A303 Amesbury to Berwick Down

TR010025

Deadline 2
8.10.6 Design (De.1)

Design (De.1)

PROPOSED BORED TUNNEL - (WORK No. 1F)

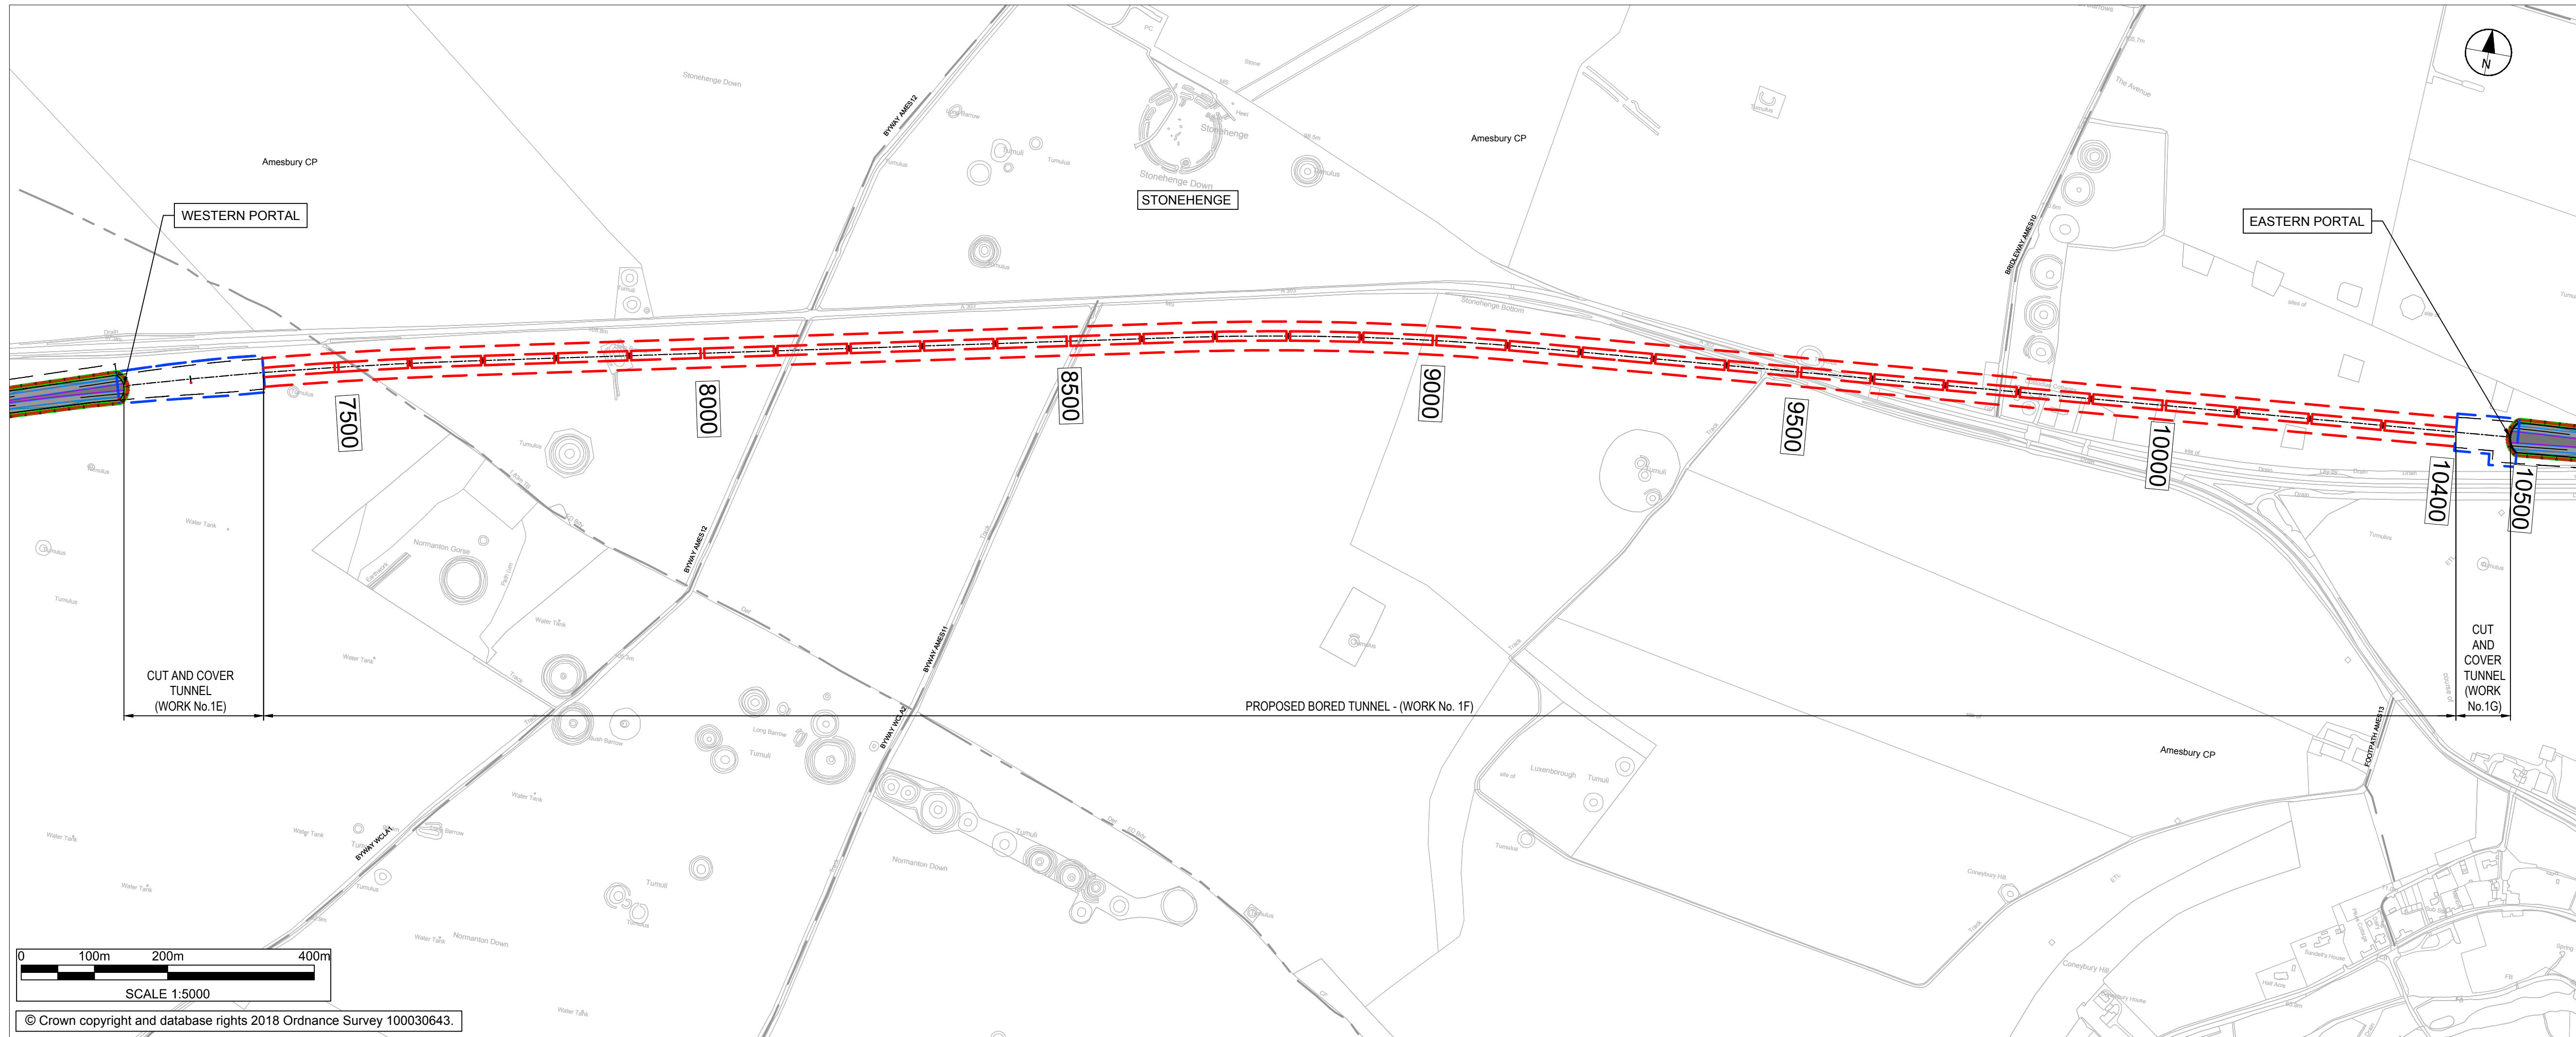
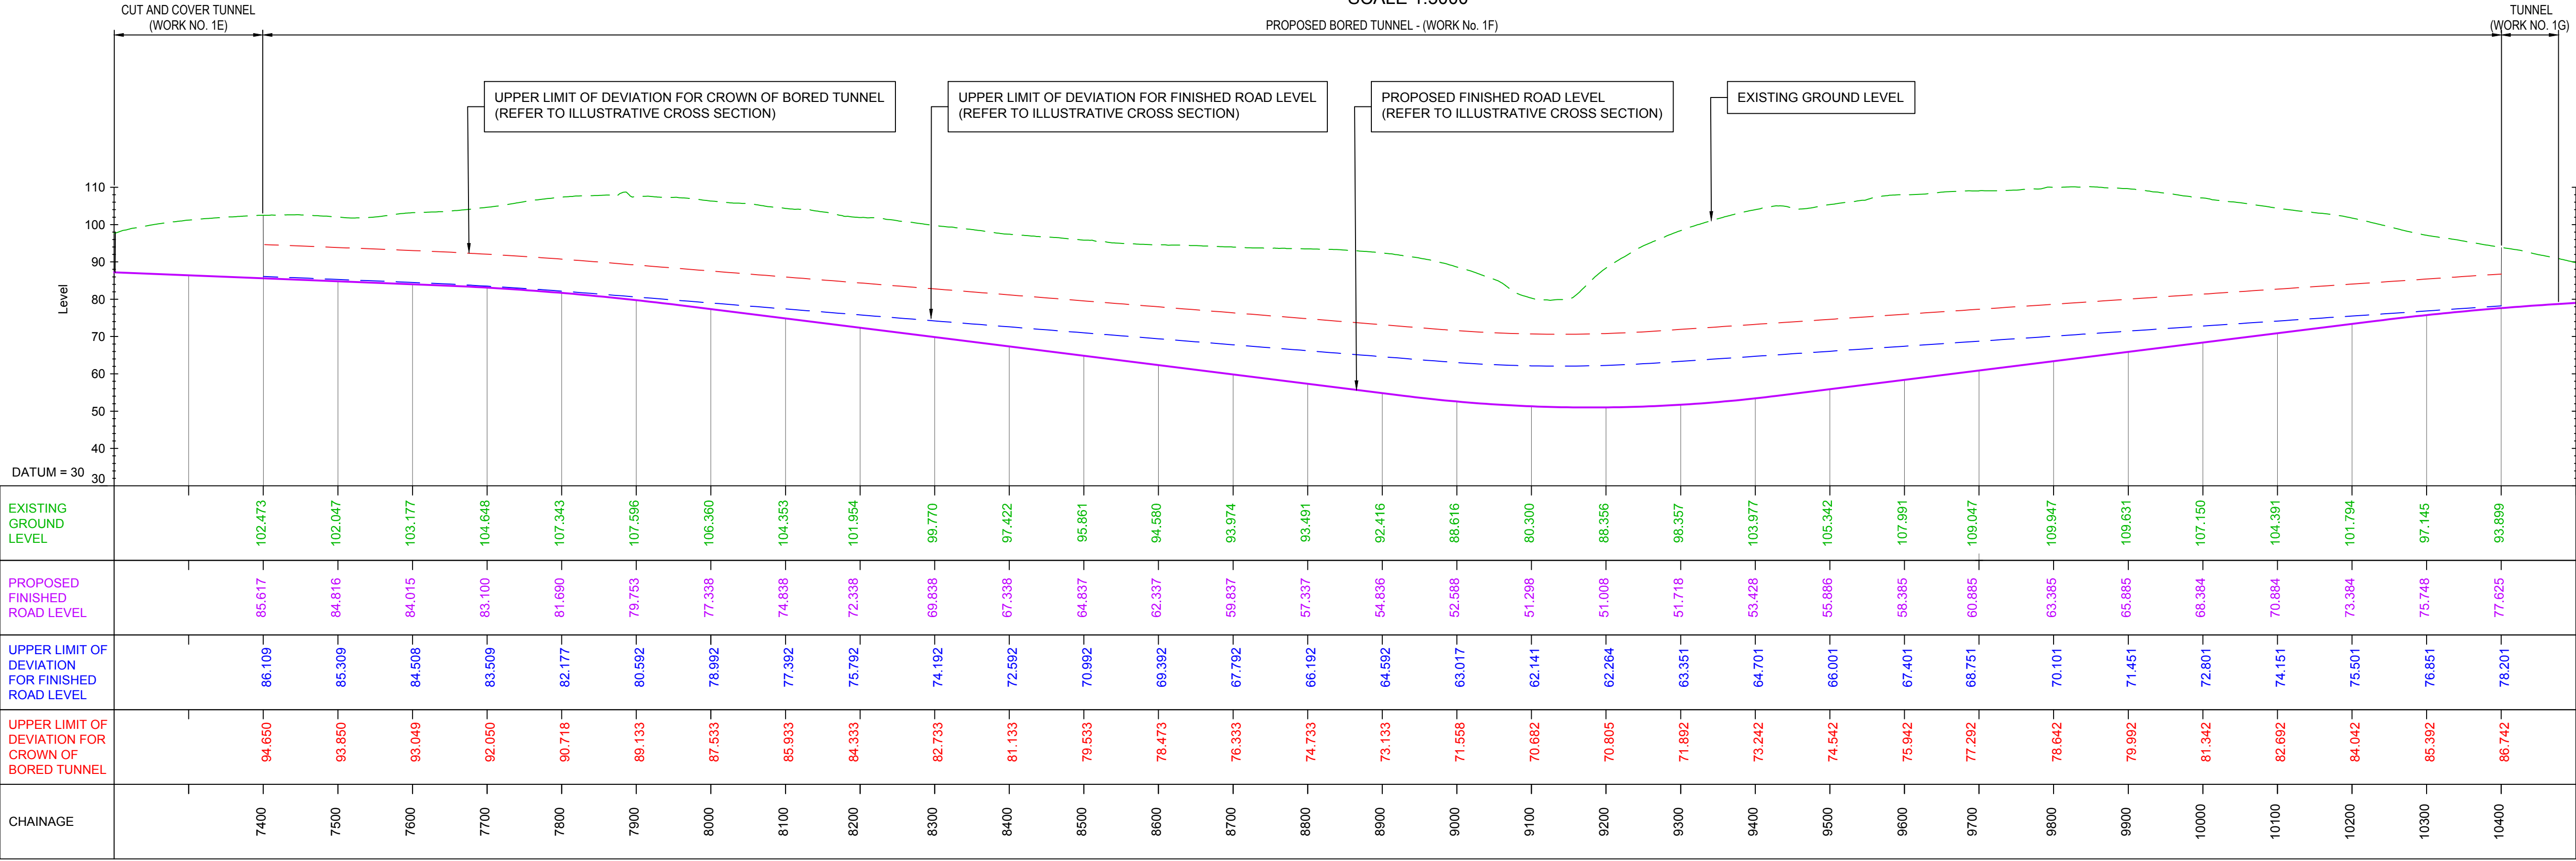
- i. The only indication of the setting out of the components within the scheme appears to be the longitudinal chainage shown at 500m intervals on the various layout drawings, following the general route of the road from west to east. There appears to be no indication of setting out laterally. It is impossible to define the intended location of the components, or to see how the LoDs, which are not shown on the drawings, would apply. Please explain.

- i. **The only indication of the setting out of the components within the scheme appears to be the longitudinal chainage shown at 500m intervals on the various layout drawings, following the general route of the road from west to east. There appears to be no indication of setting out laterally. It is impossible to define the intended location of the components, or to see how the LoDs, which are not shown on the drawings, would apply. Please explain.**

1. The lateral layout of proposed road scheme elements is shown by means of a centreline on the Works Plans [APP-008], in accordance with Regulation 5(2)(j) of the Infrastructure Planning (Applications: Prescribed Forms and Procedure) Regulations 2009 (APFP Regulations) which requires the Applicant to show, for a linear scheme (such as this) the proposed route and alignment of the development and works, in relation to existing features. The limit of deviation applicable to the linear works is prescribed by article 7(3) of the draft DCO [APP-020], which permits variation of the position of the centreline by up to 3 metres either side of the centreline as shown on the Works Plans. As the scale of the Works Plans is 1:2500, the Applicant has elected, in the interests of clarity, not to show these 3 metre parallel limits either side of the centreline; however, having regard to the scale of the Works Plans it is clear that the degree of variance permitted is small. The proposed locations of non-linear works are shown on the Works Plans by way of the limits of deviation for those works. This approach (in relation to limits of deviation for both linear and non-linear works) has precedent in the made Silvertown Tunnel Order 2018. Further details of road elements are provided on the Engineering Section Drawings (plan and profiles) [APP-010] and Engineering Section Drawings (cross sections) [APP-011], which, in accordance with APFP Regulations 5(2)(p) and (6)(2) show, by reference to Chart Datum, the

levels of the proposed works. Article 7 to the draft DCO [APP-020] prescribes the vertical (upwards/downwards) limits of deviation applicable to each numbered work (or component element thereof). The chainage references, which feature in both the 'plan' parts and the 'profiles' parts of the Engineering Section Drawings (Plan and Profiles) [APP-010] provide readers with a means of linking the cross-sectional information with what is shown in 'plan' view. When read in combination, the above-mentioned application documents create a three-dimensional 'envelope' within which appropriate design refinement may be considered during detailed design. For more detailed guidance on the interpretation of the above-mentioned DCO application documents, please refer to the Applicant's DCO application 'signposting' document [AS-009], and in particular Appendix A thereof.
